From: Ben Tidey <[REDACTED]>
Sent: 20 March 2018 15:52
To: Amber Willard
Cc: [REDACTED]
Subject: RE: Y/1/18/TC

I write in relation to the application Y/1/18/TC at Berri,Court, Yapton.

## BERRICOURT TREE PLAN

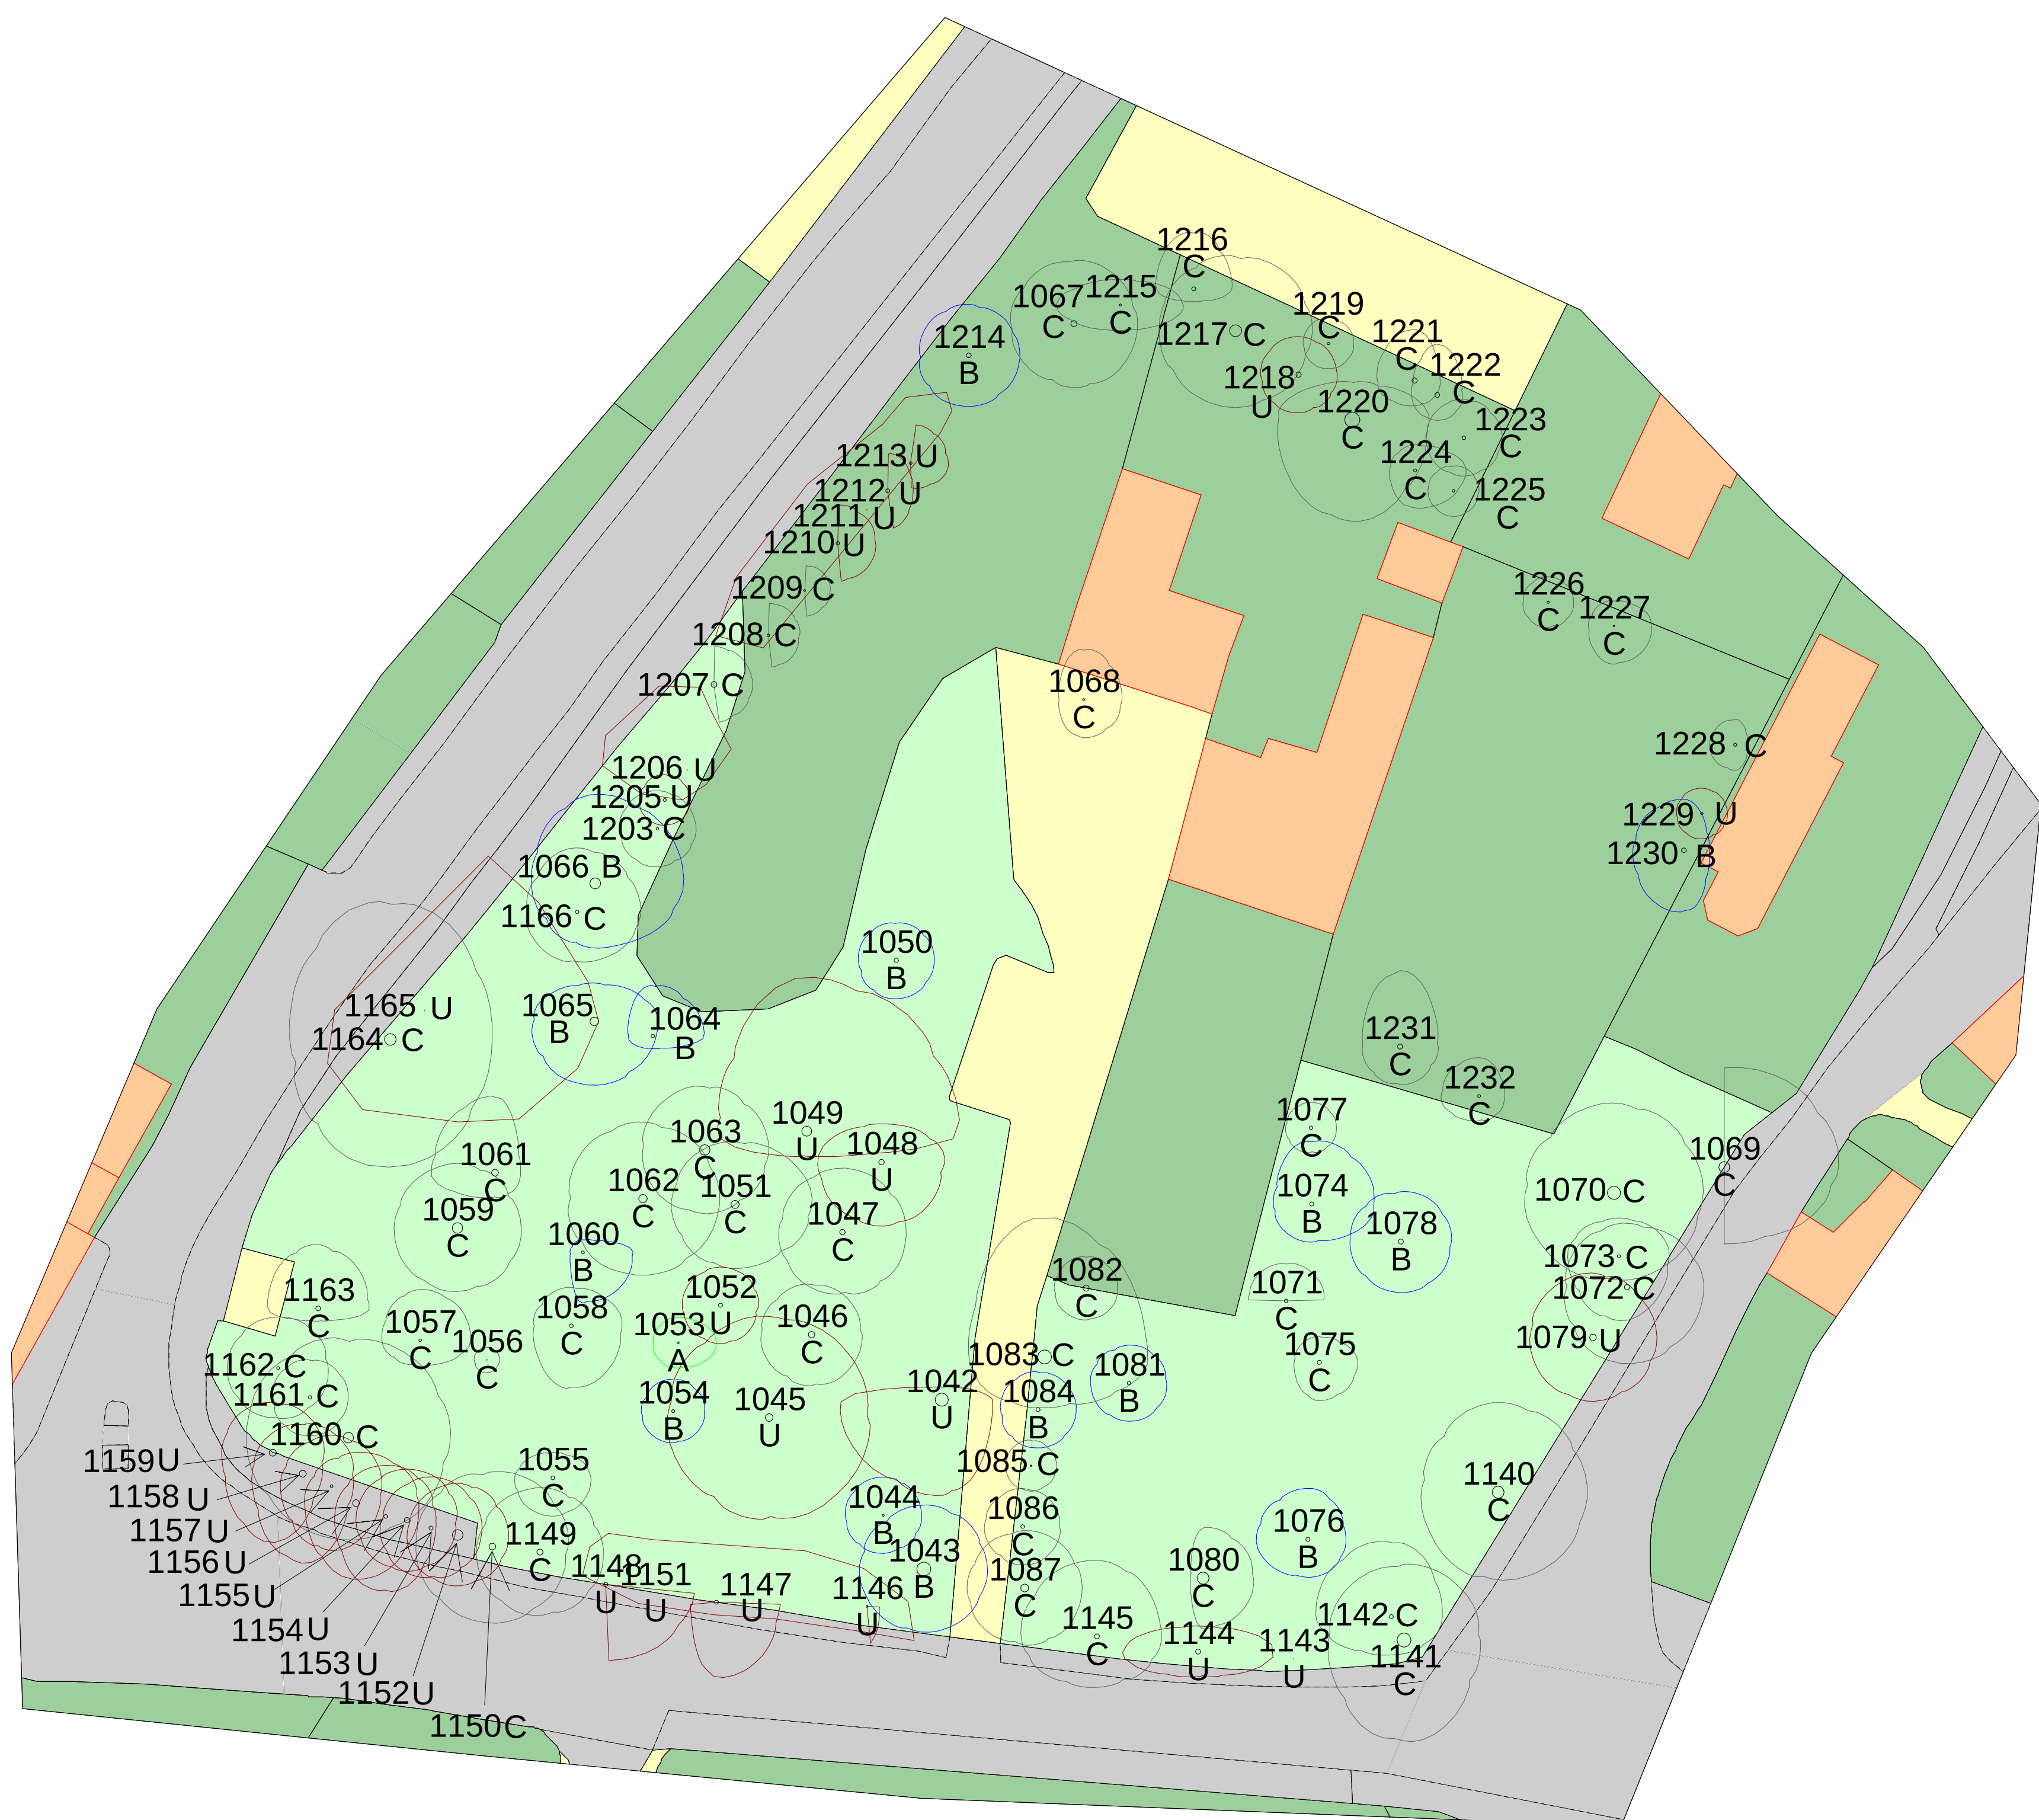
Hi Amber, thanks for taking my call this afternoon.
Further to a conversation and in response to your email of 19-03-2018.
I have spoken to my client and we would like to remove tree No 88 Tag 1217 Eucalyptus from our application.

The vast majority of works he has no objection to however there is one tree ' No 88 Tag 1217 Eucalyptus' in which he wants to make a TPO as it meets the relevant criteria which I attach for information.
